Ambrosden Parish Council

Planning Response

Application No.: 22/02866/OUT

Proposal: OUTLINE planning application for up to 120 dwellings, vehicular and pedestrian access off Ploughley Road, new pedestrian access to West Hawthorn Road, surface water drainage, foul water drainage, landscaping, public open space, biodiversity and associated infrastructure. Access off Ploughley Road is not reserved for future consideration

Drawing Title
**Parameter Plan
Access**

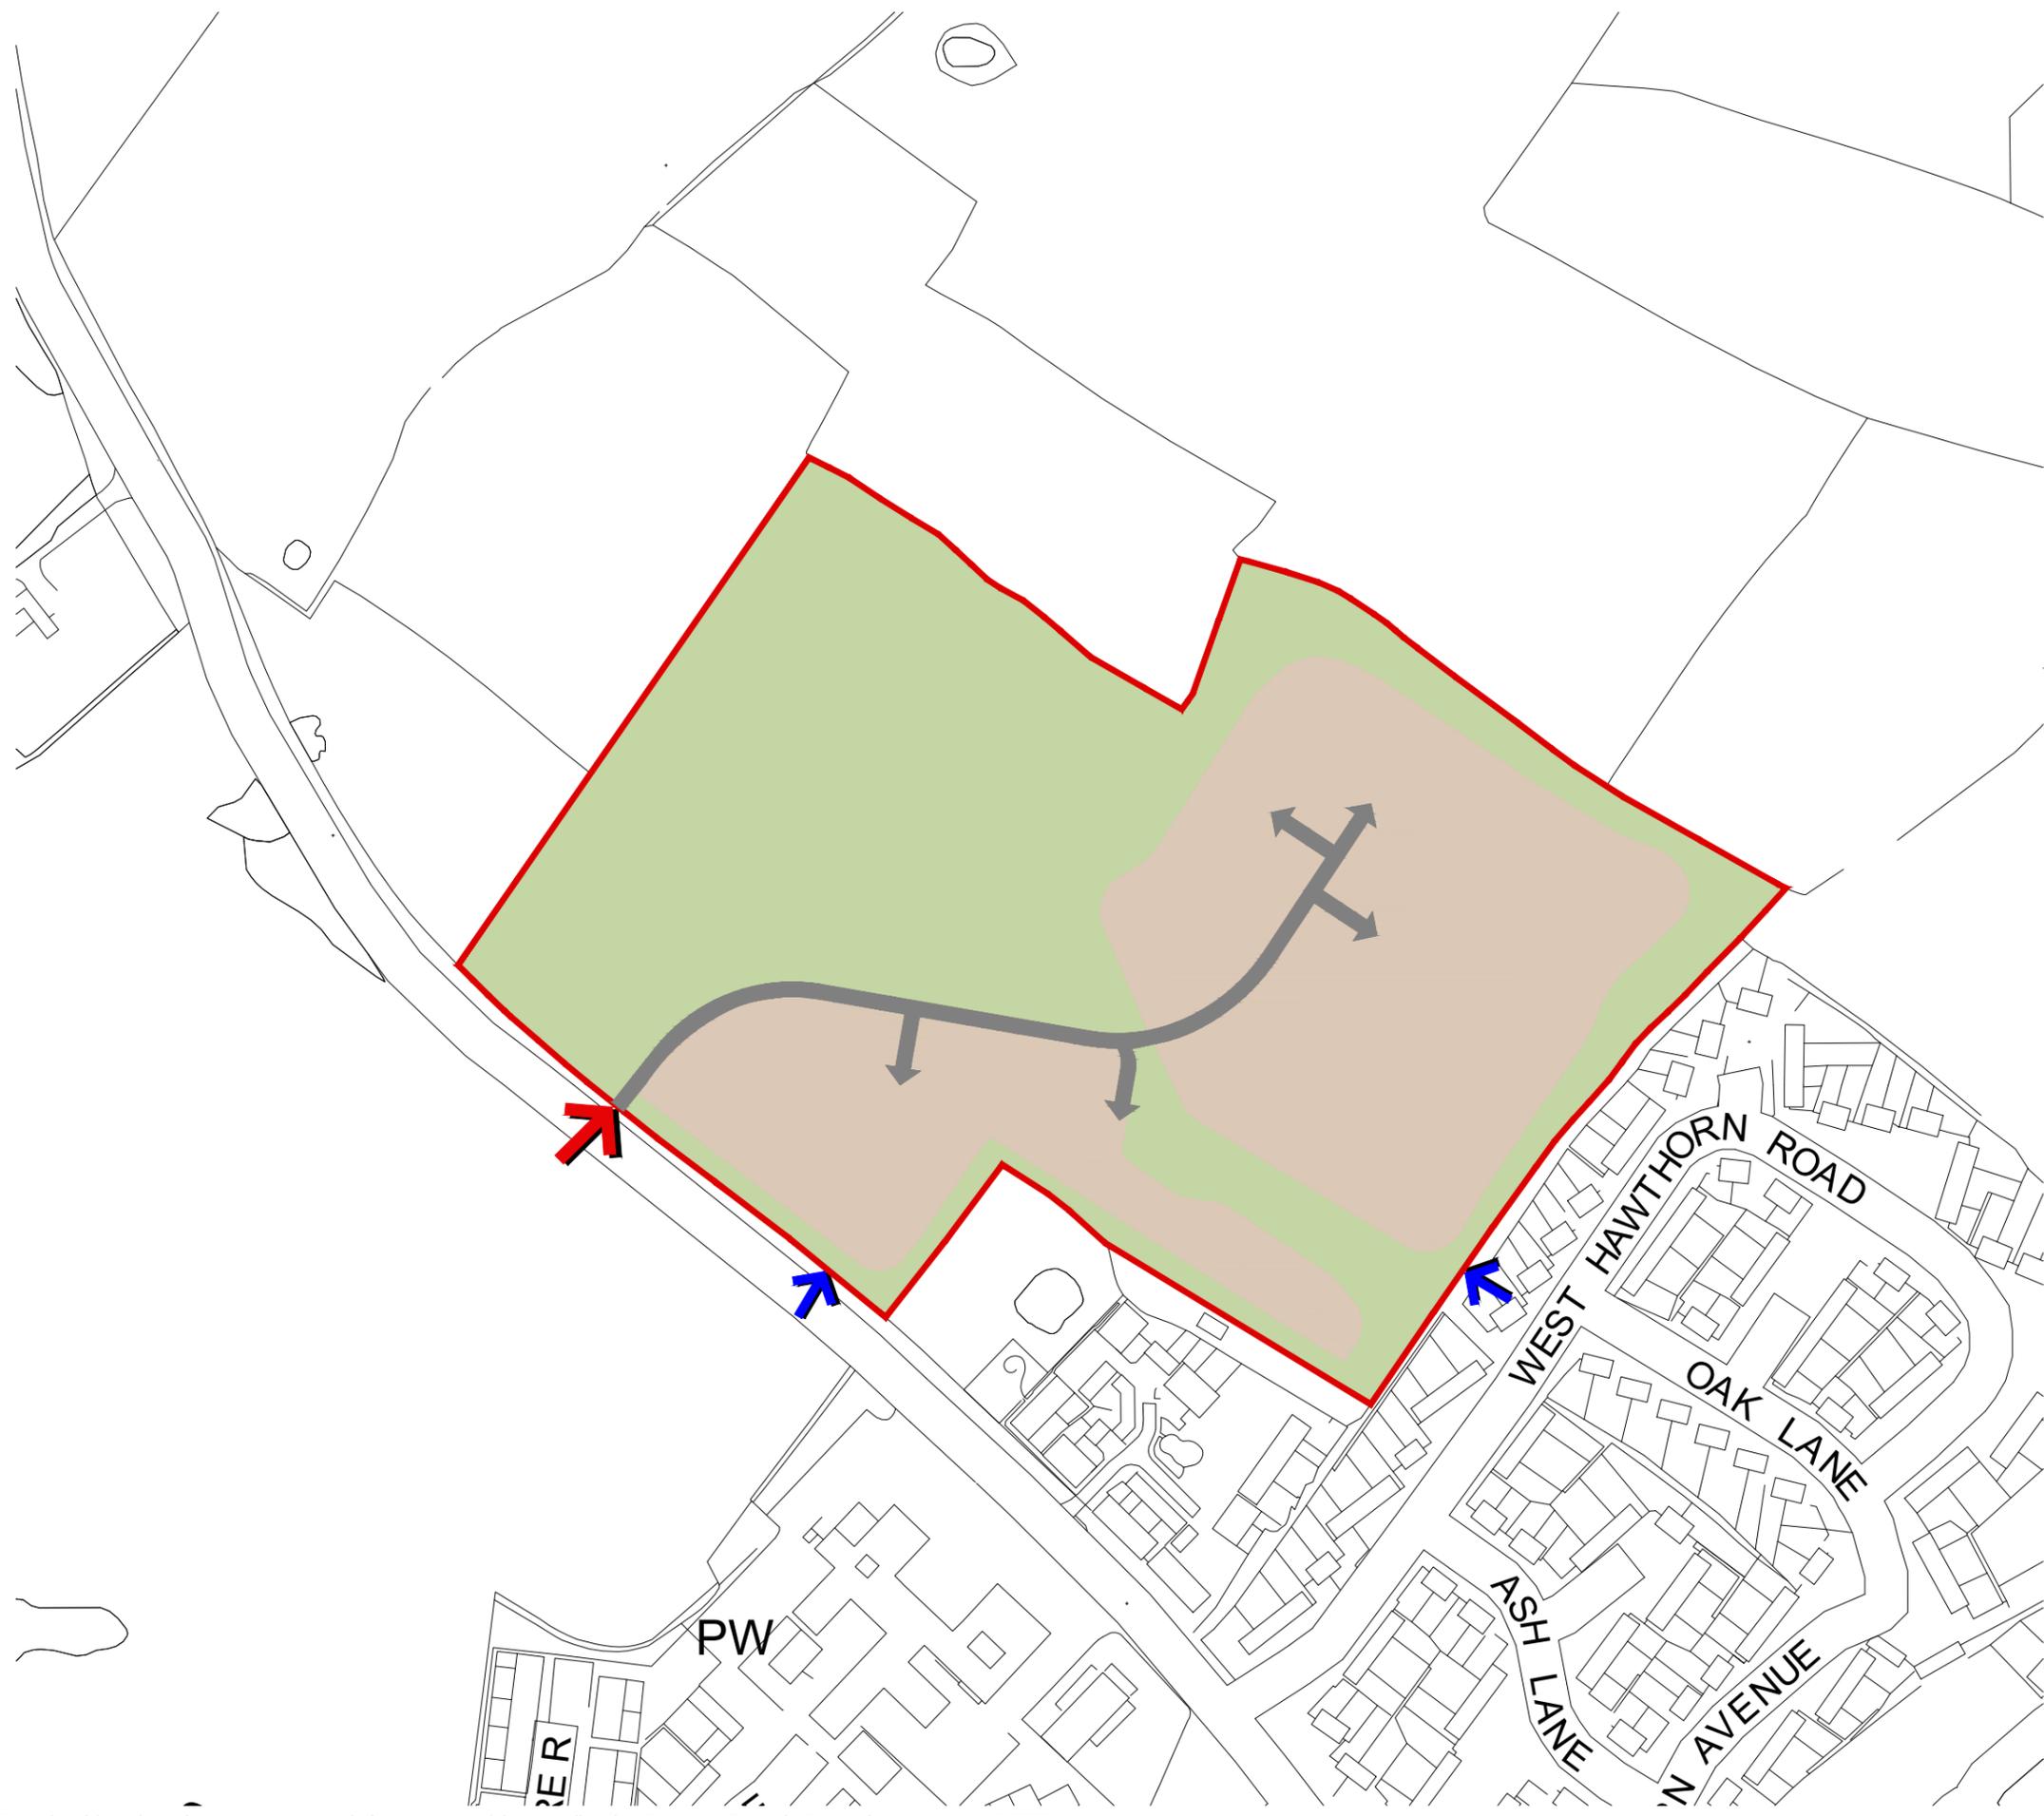
It appears that there are plans to remove trees and/or bushes and build a path which will cut into the current path which runs along the back of West Hawthorn Road. There is also a path which runs to the side of two current properties. The potential increase in people using these two parts will cause additional disturbance to these residents.

JUNCTION VISIBILITY  
SCALE 1:250

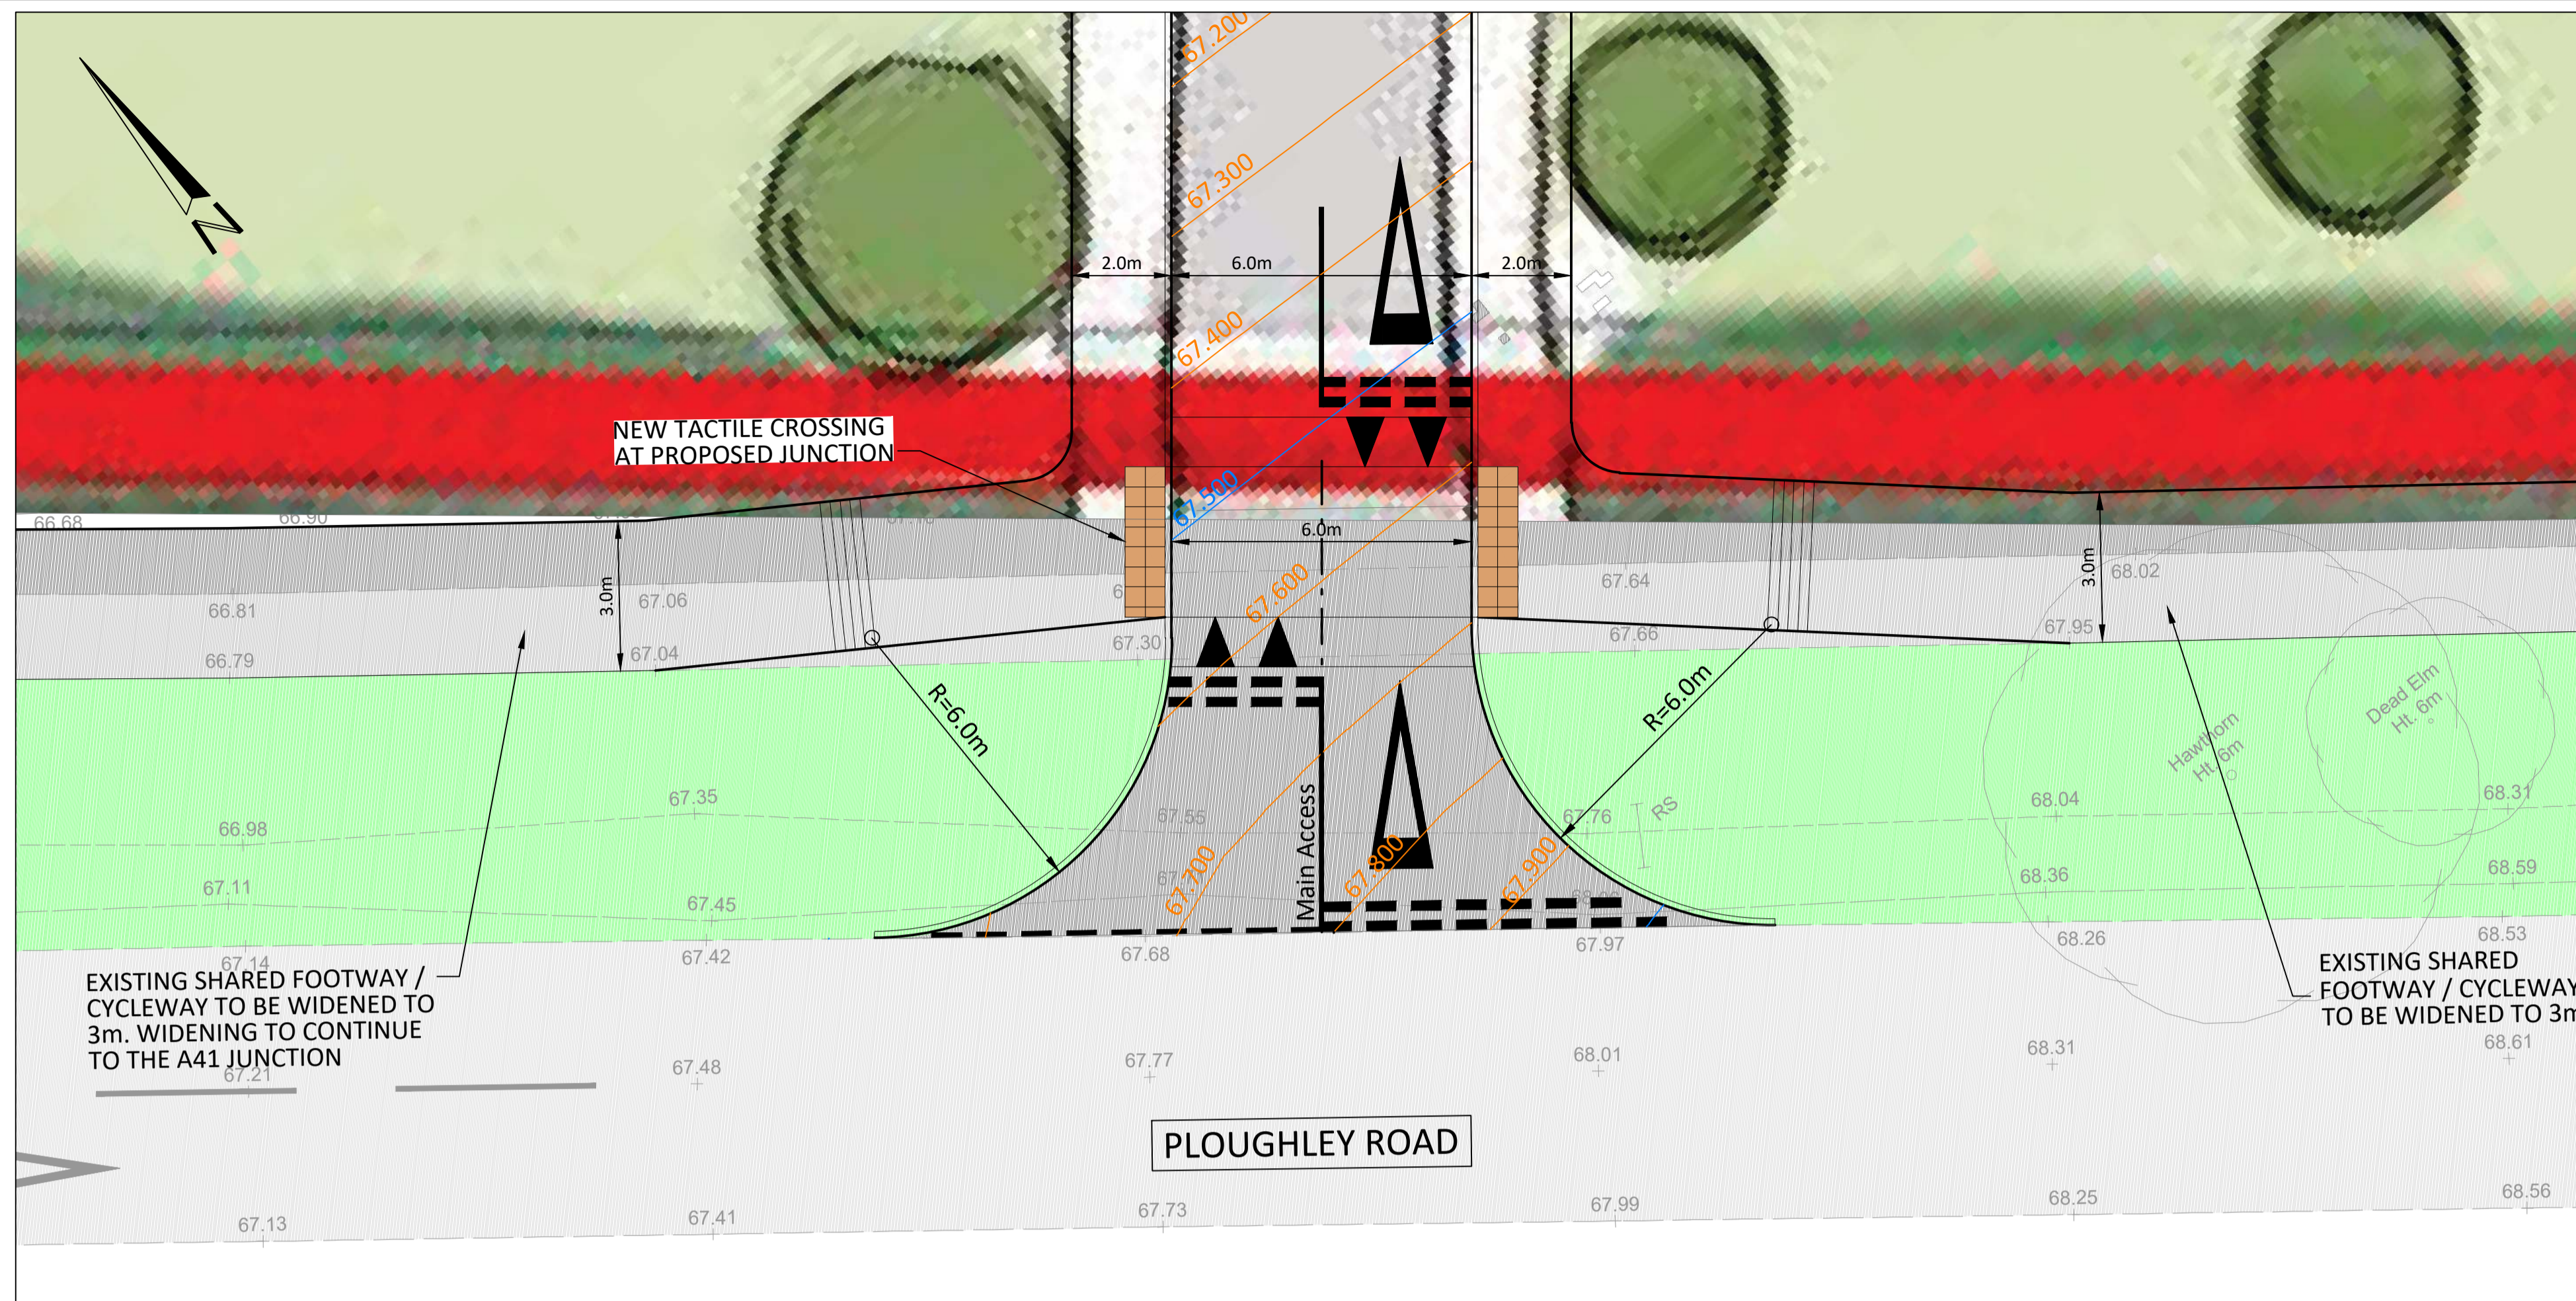
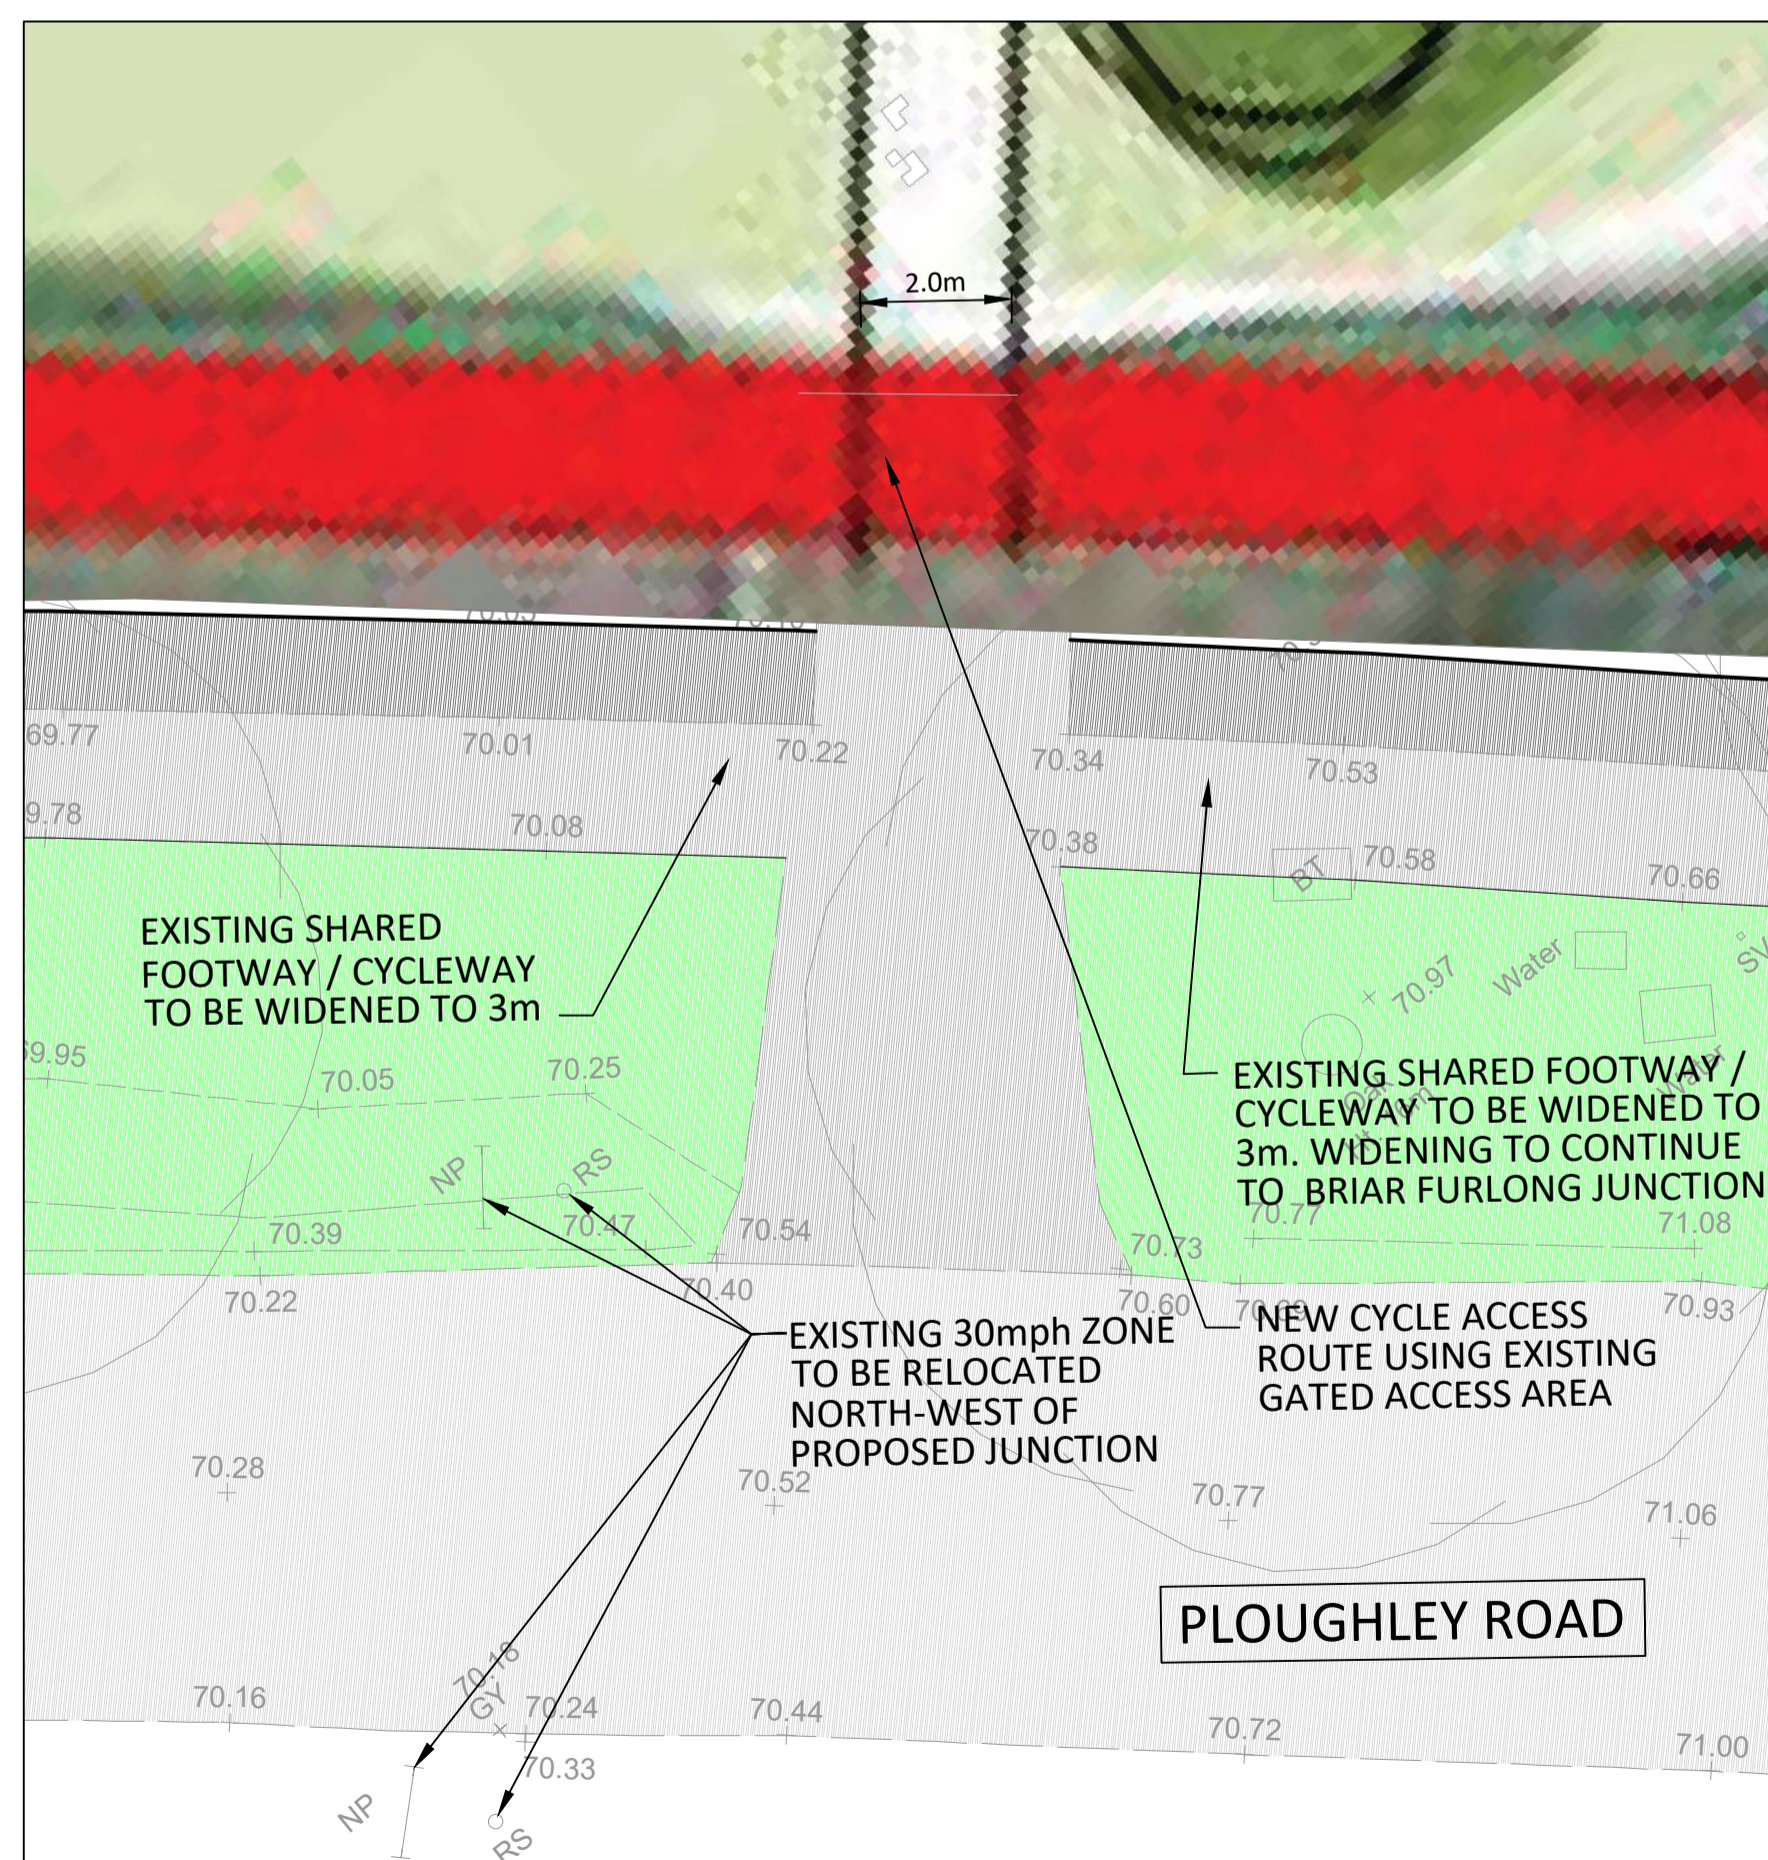
The bend in the road to the north of the entrance to the site means that visibility will be limited for residents pulling onto Ploughley Road to turn either way. With the number of vehicles travelling in both

directions on this road, safety for residents and through traffic will be compromised.
